DELEGATED HOUSEHOLDER DECISION

Item No.	Report of the Head of Development Management and Building Control	
Address:	43 ROCHESTER ROAD NORTHWOOD	
Development:	Erection of a single storey front, rear and side extension including infill of front porch and patio to rear, following demolition of existing rear conservatory. Conversion of roof space to habitable accommodation including roof extension with conversion of roof from hip to half gable ends, rear dormer and roof lights. Alterations to front driveway, fenestration and materials.	
LBH Ref Nos:	78160/APP/2024/2562	
Drawing Nos:	644/P3/1 644/P3/3 644/P3/4	
Date Plans received:	24-09-24	Date(s) of Amendments(s):
Date Application valid	24-09-24

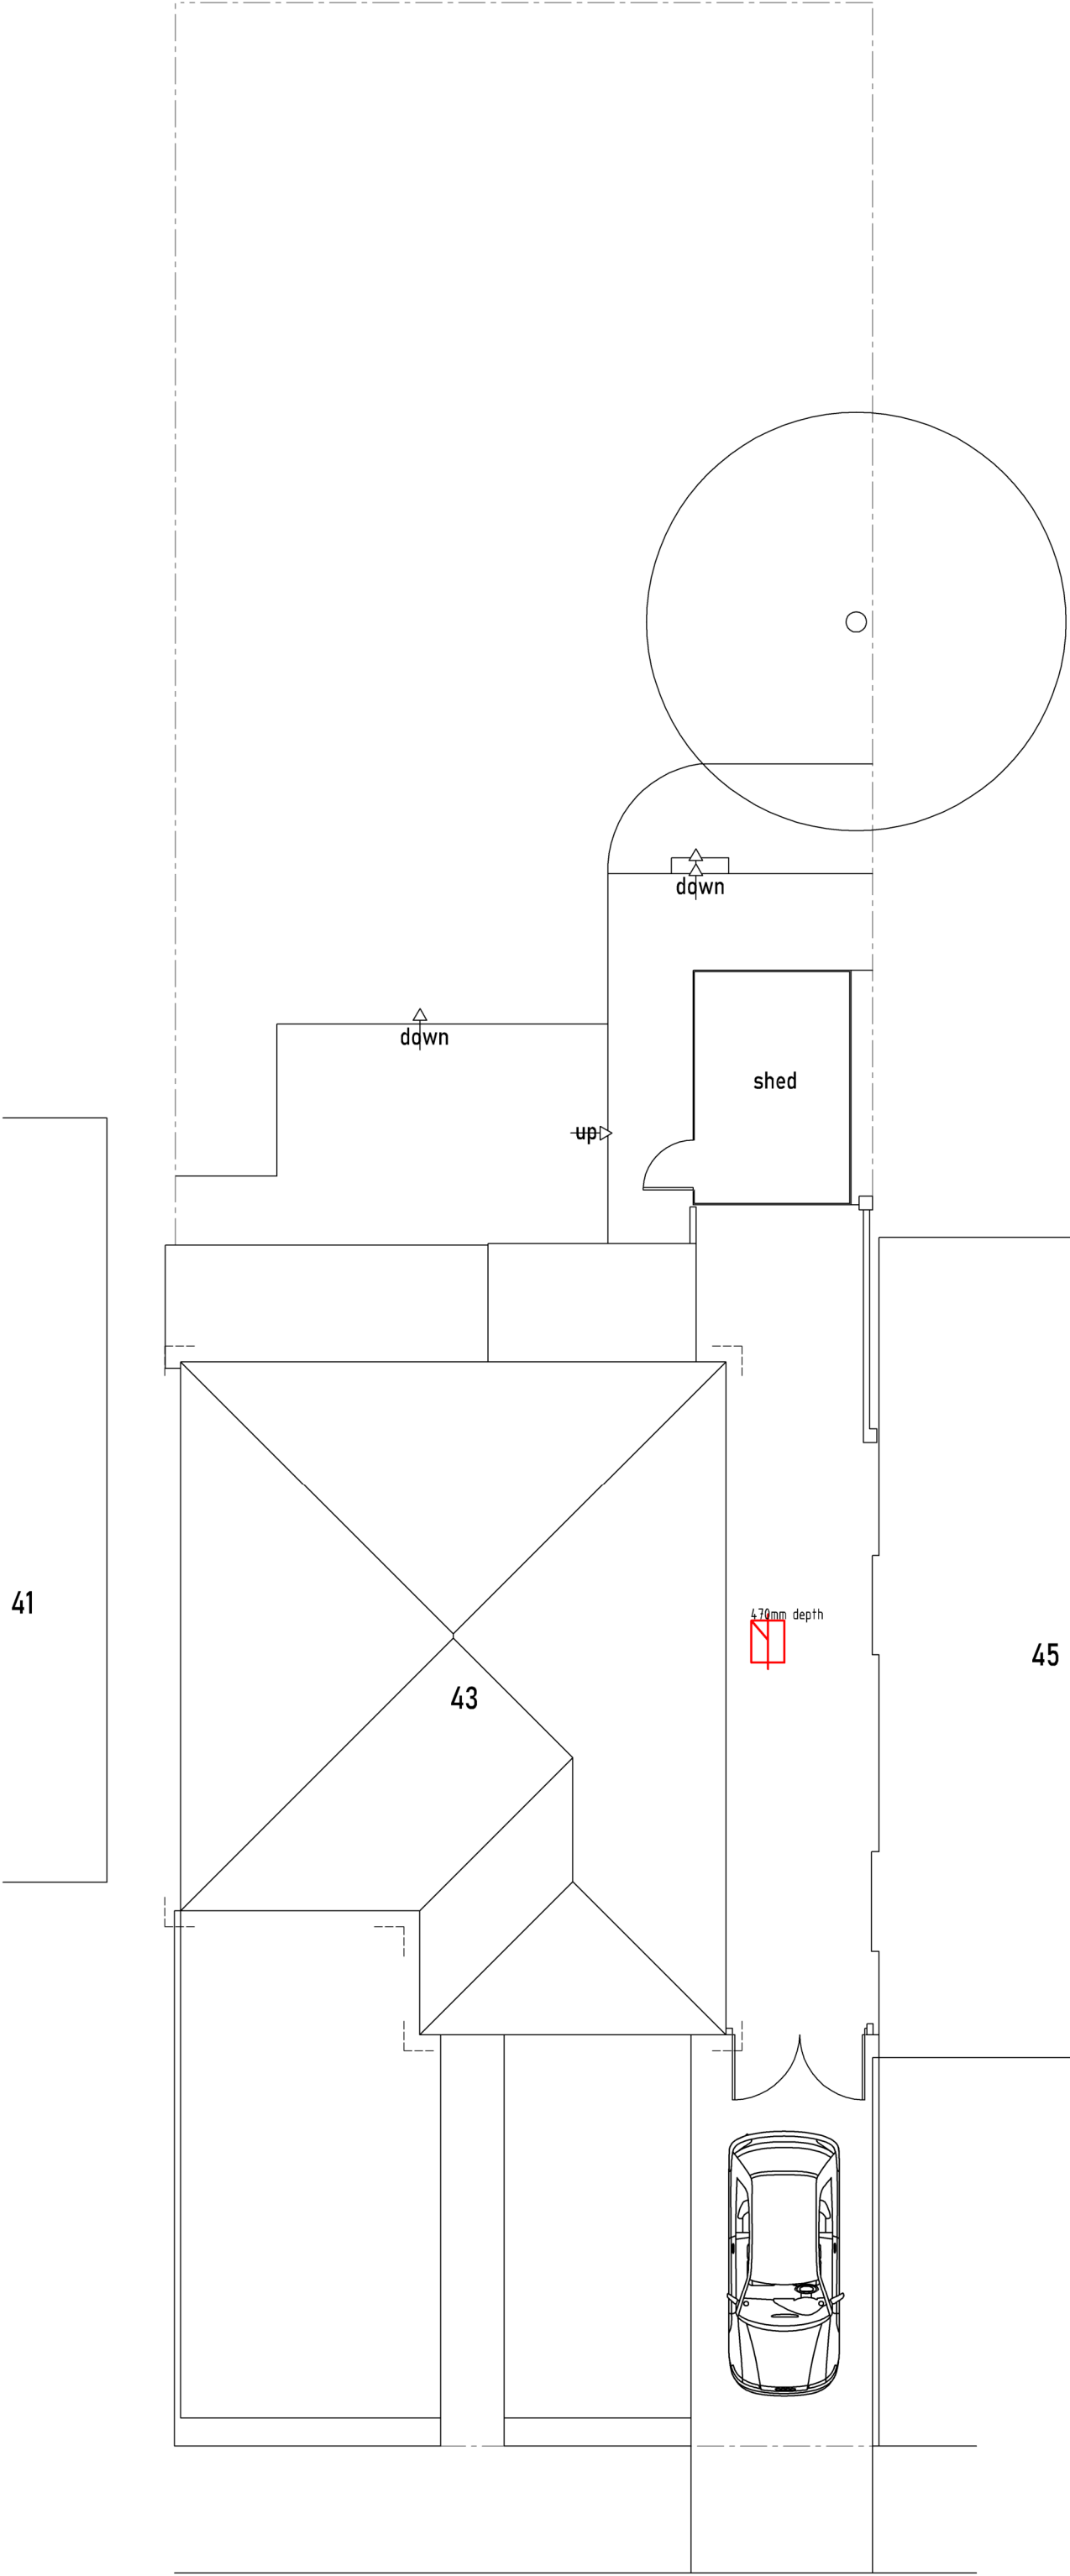
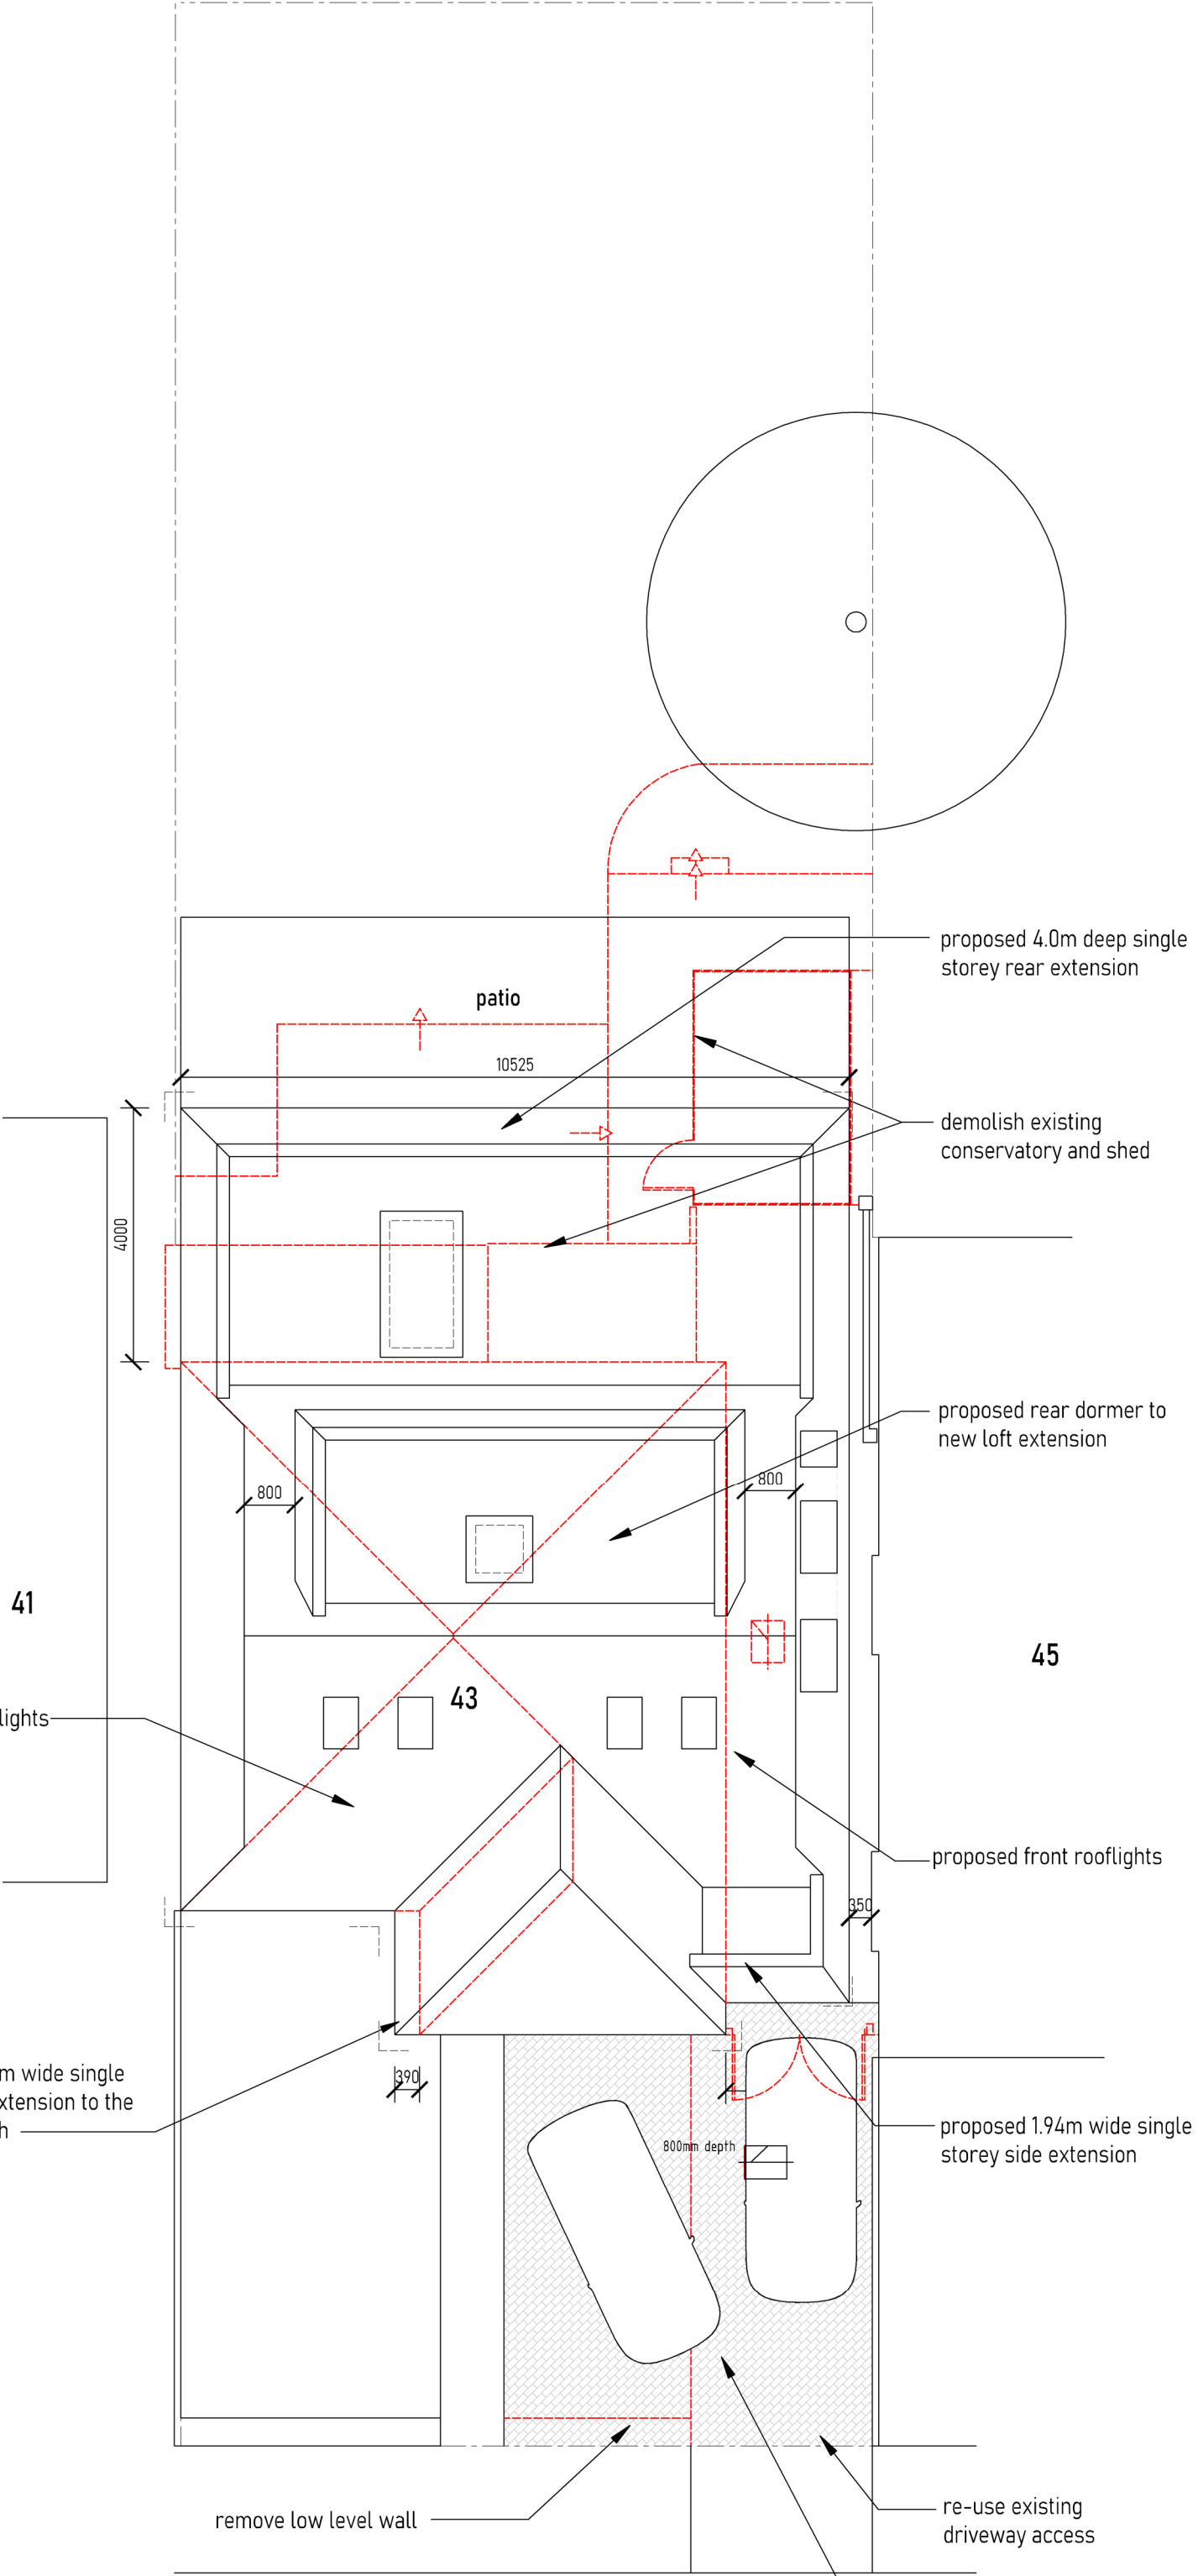
It is also noted there are discrepancies in the plans as the site and roof plan (644/P3/1) show two front hipped roof dormers, which are not shown on the floor plans nor the elevations. It is assumed this is a drawing error as front dormers were recently refused (ref: 78160/APP/2024/582). However, for the avoidance of doubt, any front dormer would be unacceptable and contrary to Policy DMHD 1, which states roof extensions should be located on the rear elevation only. In addition, there are no front dormers within the streetscene, and therefore this would have a negative impact on the character and appearance of the area.
